CITY OF ALBUQUERQUE

October 11, 2019

Site: Top Golf, 1600 Desert Surf Cir. NE, F16E003E1
UPC 101606124107430118

Re: Drainage Ordinance (14-5-2-1) Violations for Erosion and Sediment Control

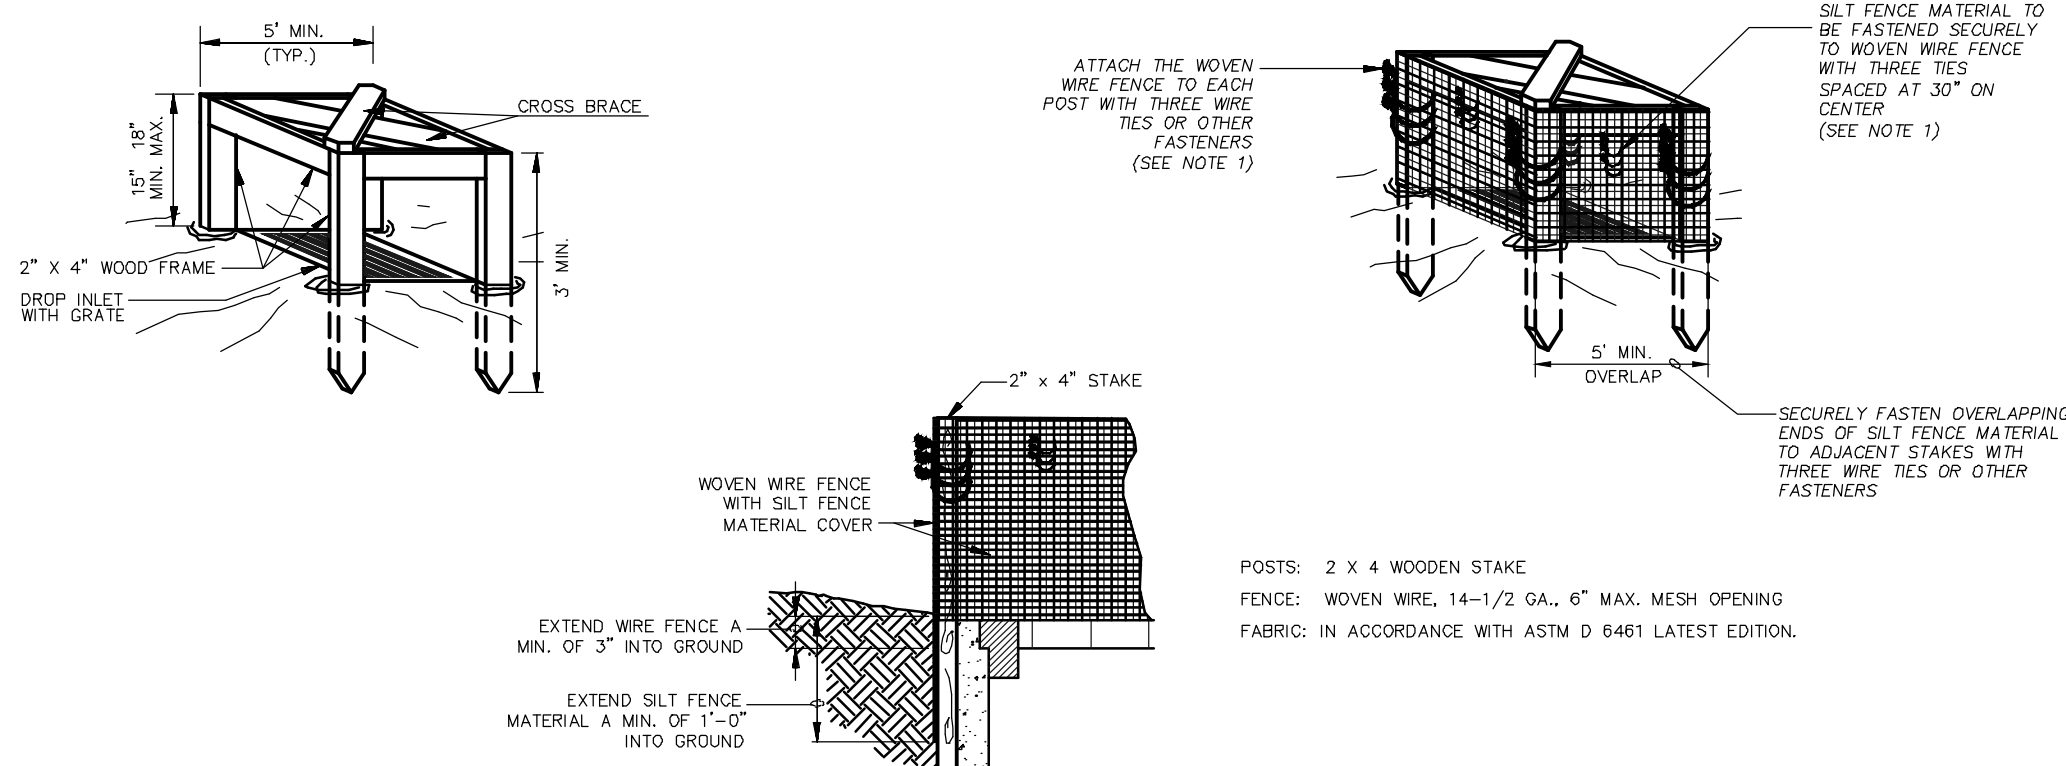
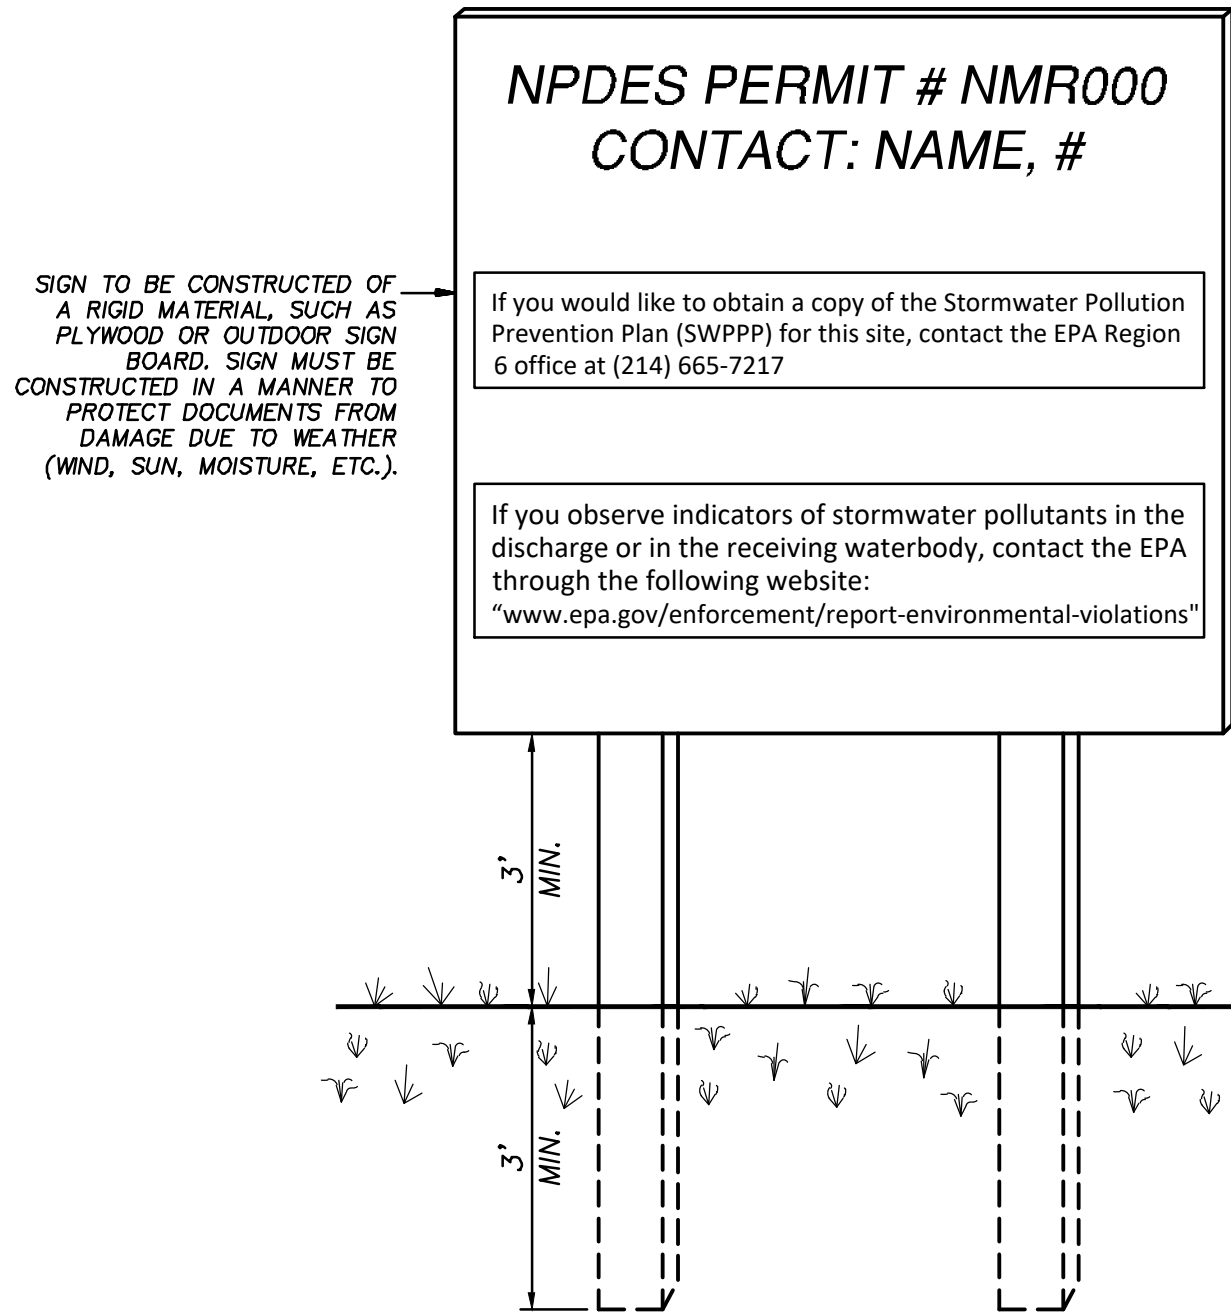
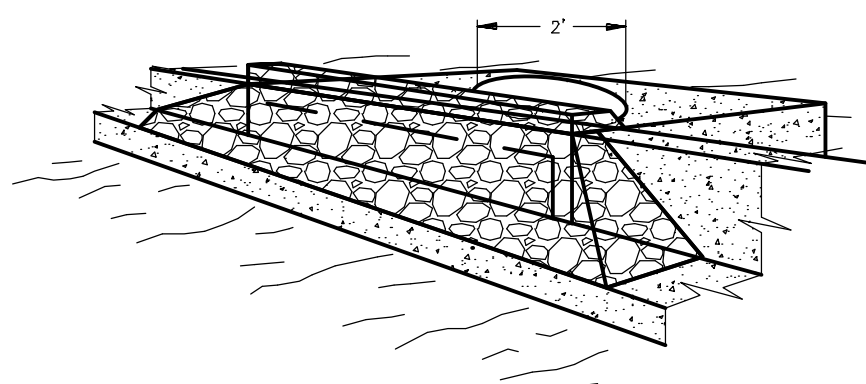
- Stormwater controls were missing (Inlet Protection, Construction Entrance, and Sediment Traps) and in need of repair (Silt Fence).
- Sediment 'Track-out' in Desert Surf Circle has been washed into the inlets
- Topgolf USA Albuquerque, LLC is the owner listed on the Building Permit but the City has not received that NOI documentation

- Provide and maintain stormwater controls.
- Provide an updated Erosion Control Plan.
- Remove all sediment from Desert Surf Circle and the downstream storm drain.
- Provide owner's NOI documentation for approval
